October 29, 2020

**RE: Chase Bank – Indian School Rd.
6670 Indian School Rd. NE
Grading and Drainage Plan
Engineer's Stamp Date: 10/08/20
Hydrology File: J18D001C**

Based upon the information provided in your submittal received 10/08/2020, the Grading & Drainage Plan **is not** approved for action by the DRB on Site Plan for Building Permit. The following comments need to be addressed for approval of the above referenced project:

PLOT DATE
11/05/20
DRAWING SCALE
1" = 10'
PROJECT NUMBER
CDC20013
SHEET NUMBER
C5.01

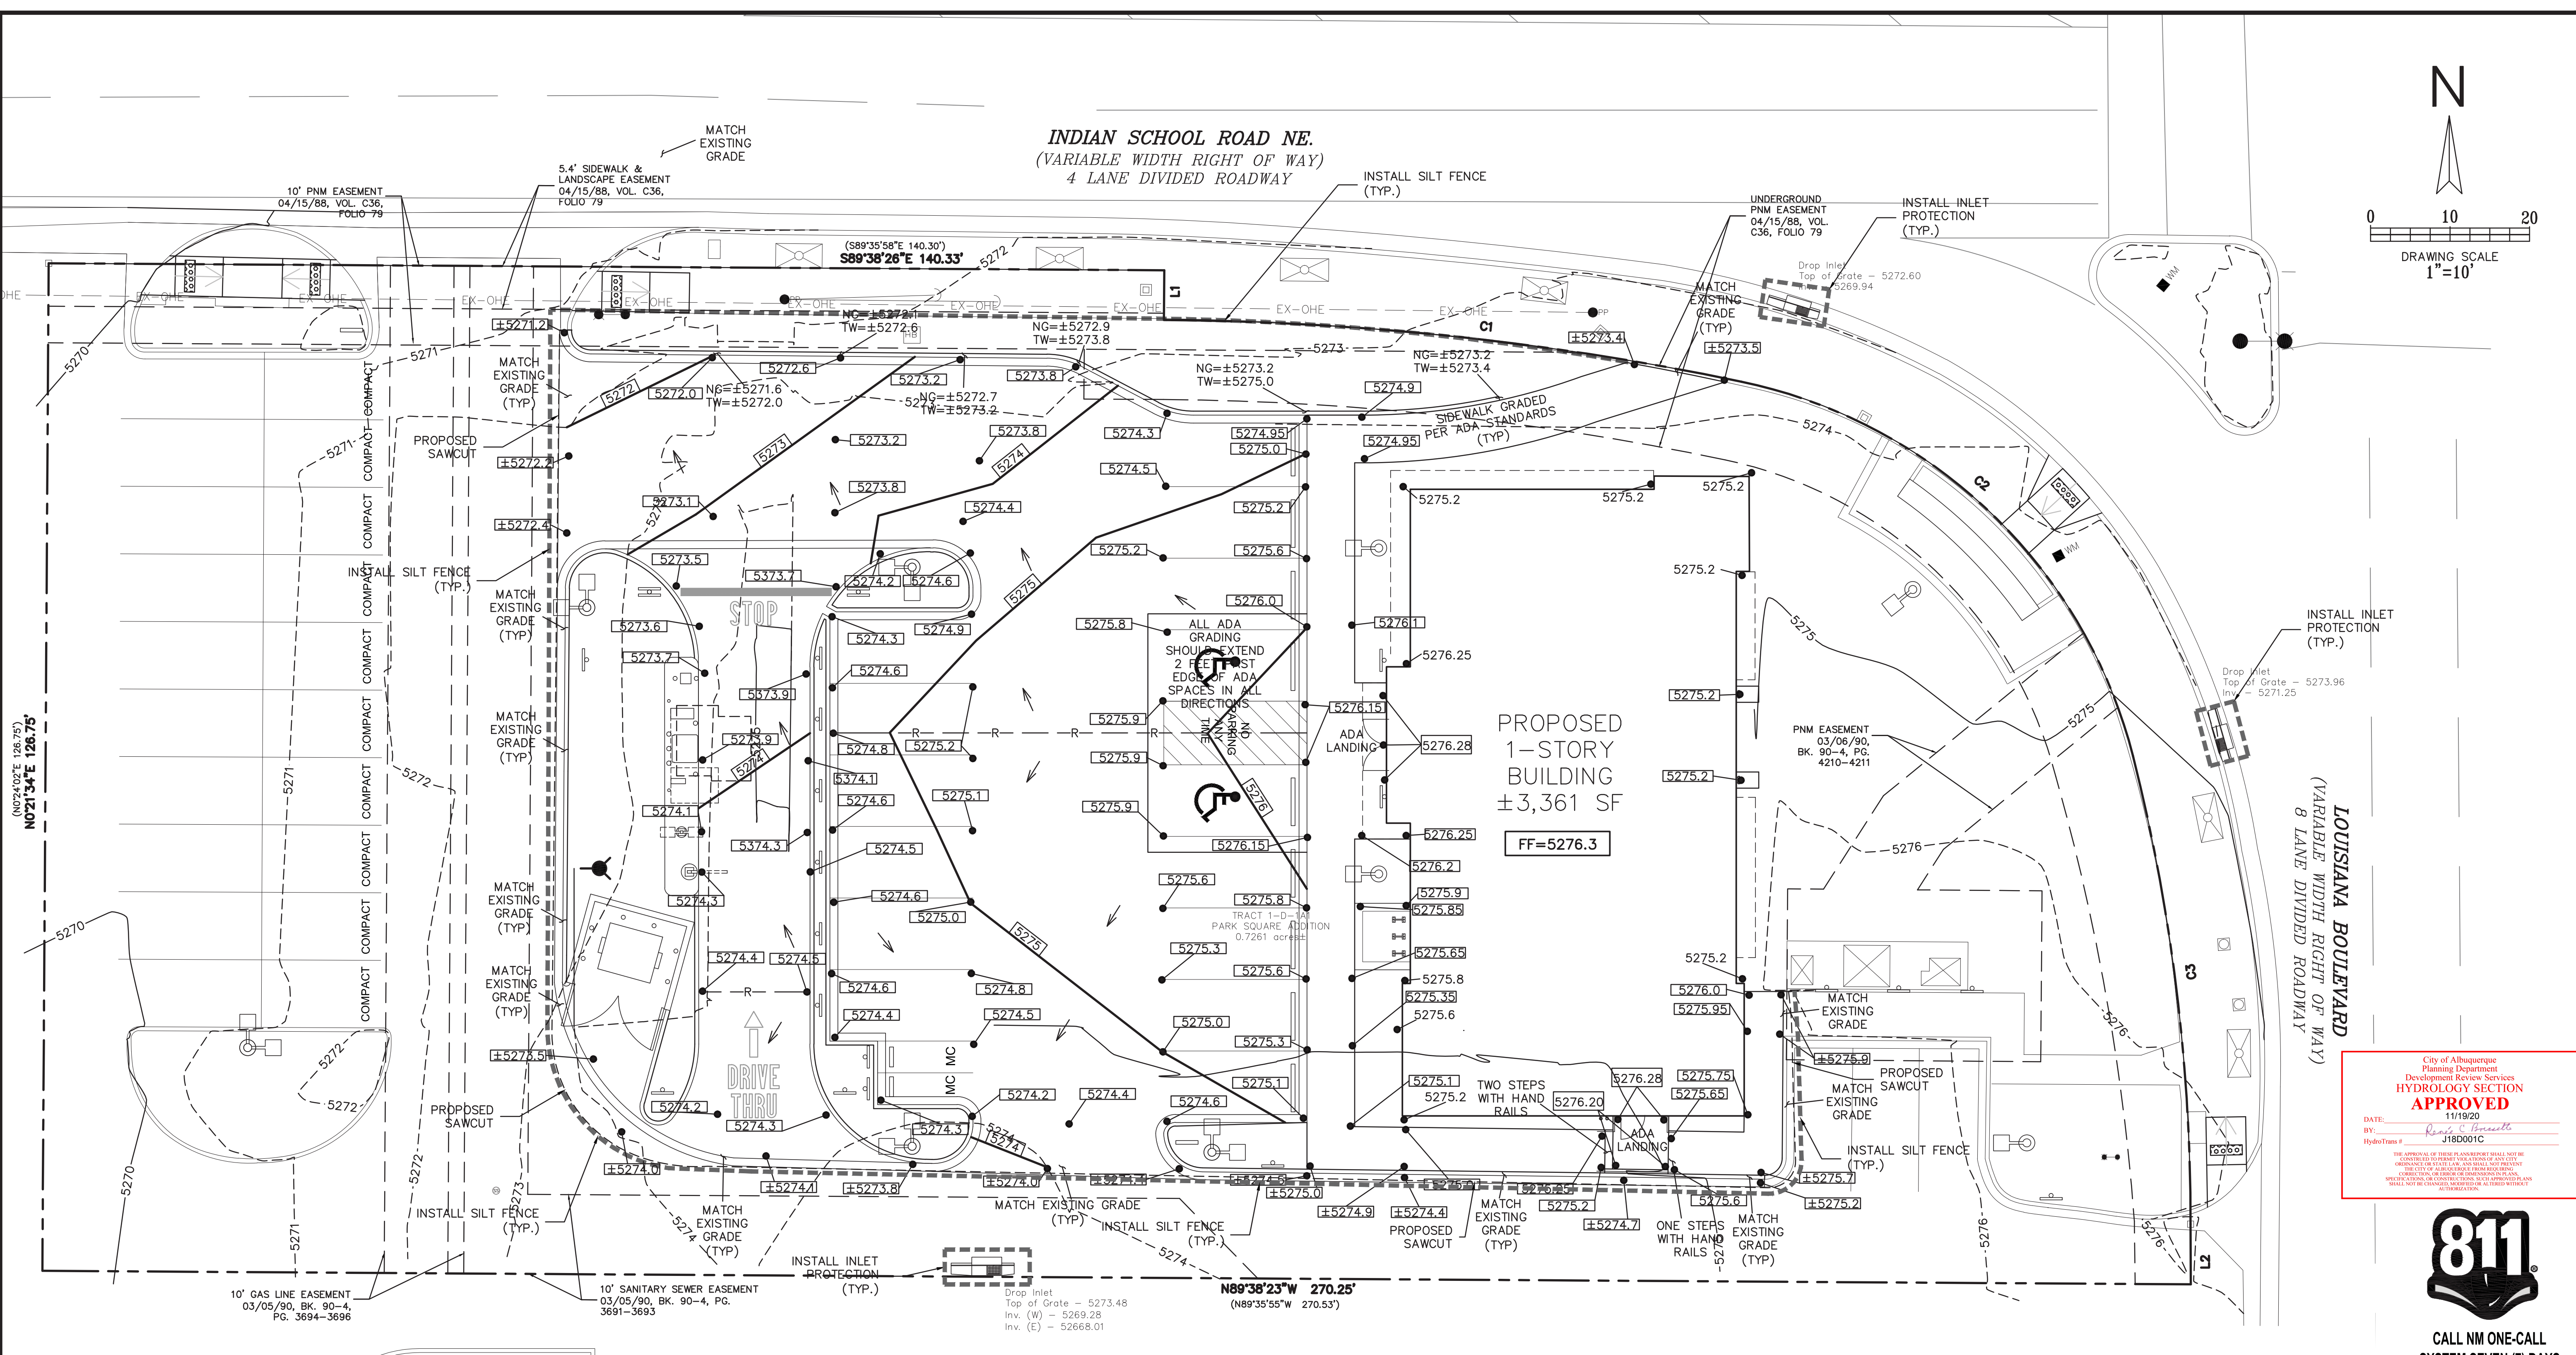
3. Please show the edge of saw cut of the existing pavement and label along this, "Match existing grades". It is currently unclear where the area of construction is starting/stopping.

4. On the Grading Plan, please shade back the existing survey points. It is hard to read what is being proposed.
5. As a reminder, if the project total area of disturbance (including the staging area and any work within the adjacent Right-of-Way) is 1 acre or more, then an Erosion and Sediment Control (ESC) Plan and Owner's certified Notice of Intent (NOI) is required to be

PLOT DATE
11/05/20
DRAWING SCALE
1" = 10'
PROJECT NUMBER
CDC20013
SHEET NUMBER
C7.01

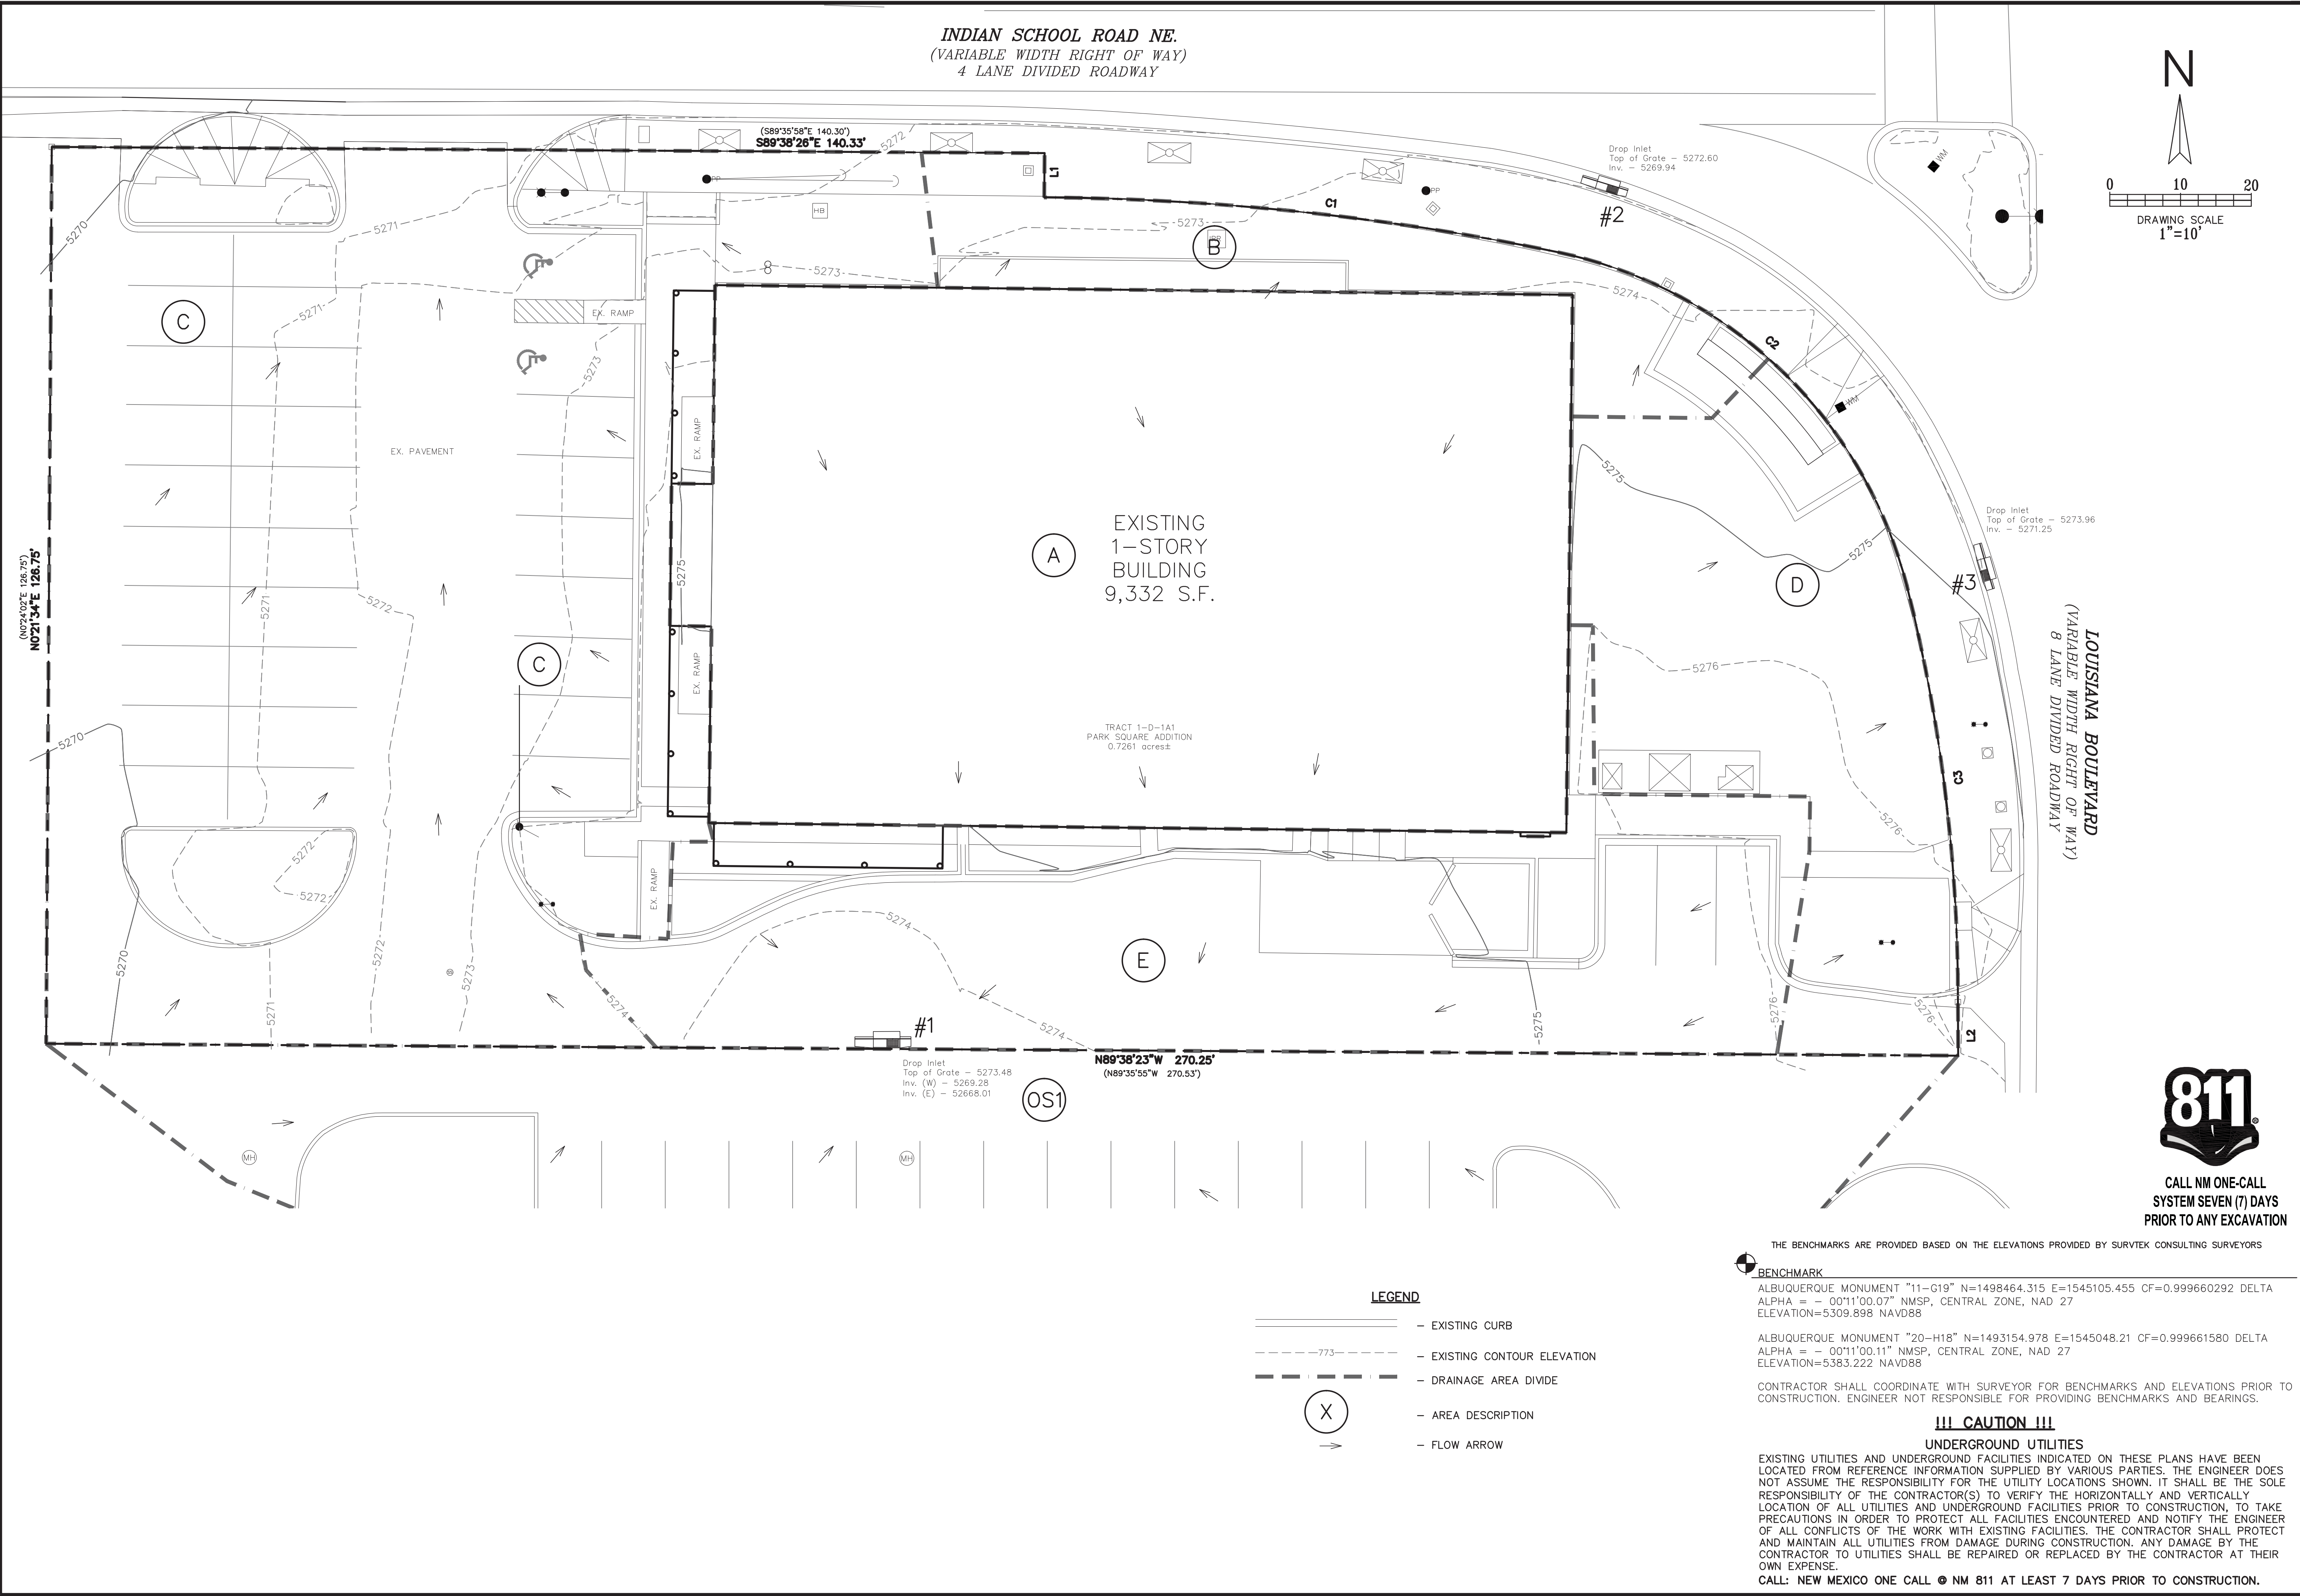
1. Please use the procedure for 40 acre and smaller basins as outlined in Development Process Manual (DPM) (signed 06/08/20) Article 6-2(a). Please provide both the existing conditions and proposed conditions for the 100-year 6 hour storm event.
